WELWYN HATFIELD COUNCIL – DEVELOPMENT CONTROL
DELEGATED REPORT

| APPLICATION No: | N6/2011/0961/FP |
| APPLICATION Site: | 107 Eddington Crescent |

The application seeks planning permission for the erection of a conservatory to the rear of the dwellinghouse.

PROPOSED SIDE ELEVATION-WEST

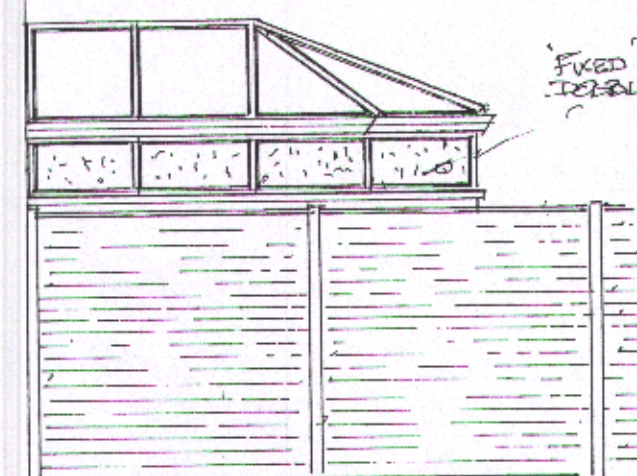
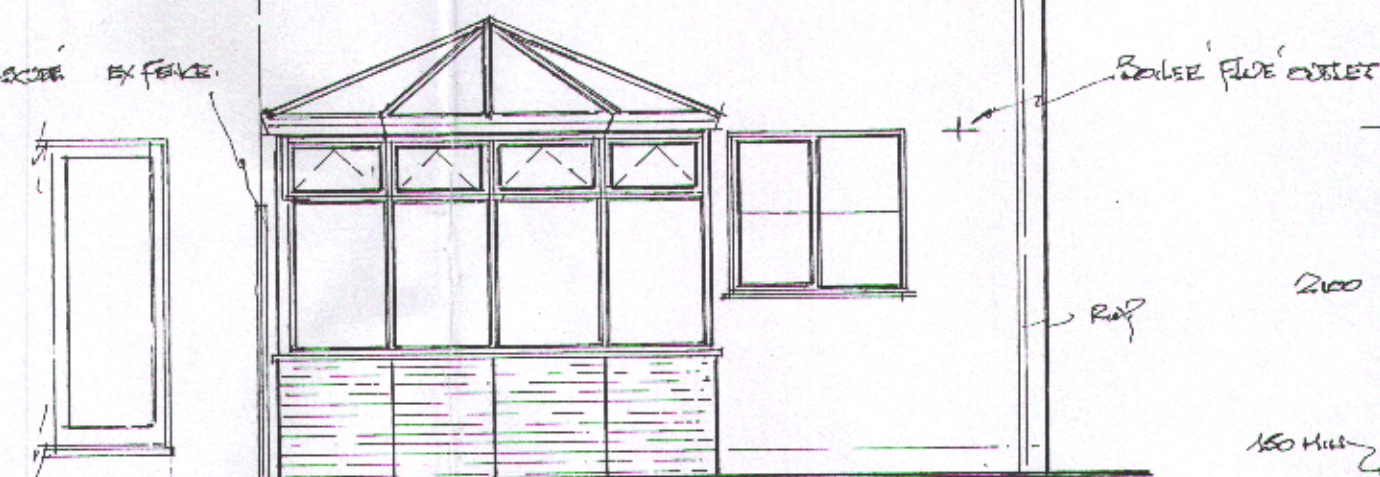
The letter of representation raised no objection the development in principle. It raised concern with the high level windows in the north western elevation and the light that would reflect from these into the adjoining site and increase the heat of the patio area.

The letter of representation raised concern with regard to the high level windows in the north western elevation and the light would reflect from them into the adjoining site – 109 Eddington Crescent. Whilst sunlight may reflect off these windows at a certain point in the day, it is not considered that this would materially increase the heat on the patio area to the rear of 109 Eddington Crescent or that this impact could be considered as a material planning consideration. Consideration could be given to the potential overlooking that could occur from these windows, which would be located above the line of the boundary fence. These windows are, however, proposed to be of obscure glazing and incapable of opening. To ensure that this is the case and to ensure that an unacceptable level of overlooking does not occur, this application will be subject to an appropriately worded condition.

3. C.5.2 - Matching Materials
4. C.7.9 - The windows proposed in the north western elevation of the conservatory shall be glazed with obscured glass and shall be fixed so as to be incapable of being opened below a height of 1.8 metres above floor level, and shall be retained in that form thereafter.
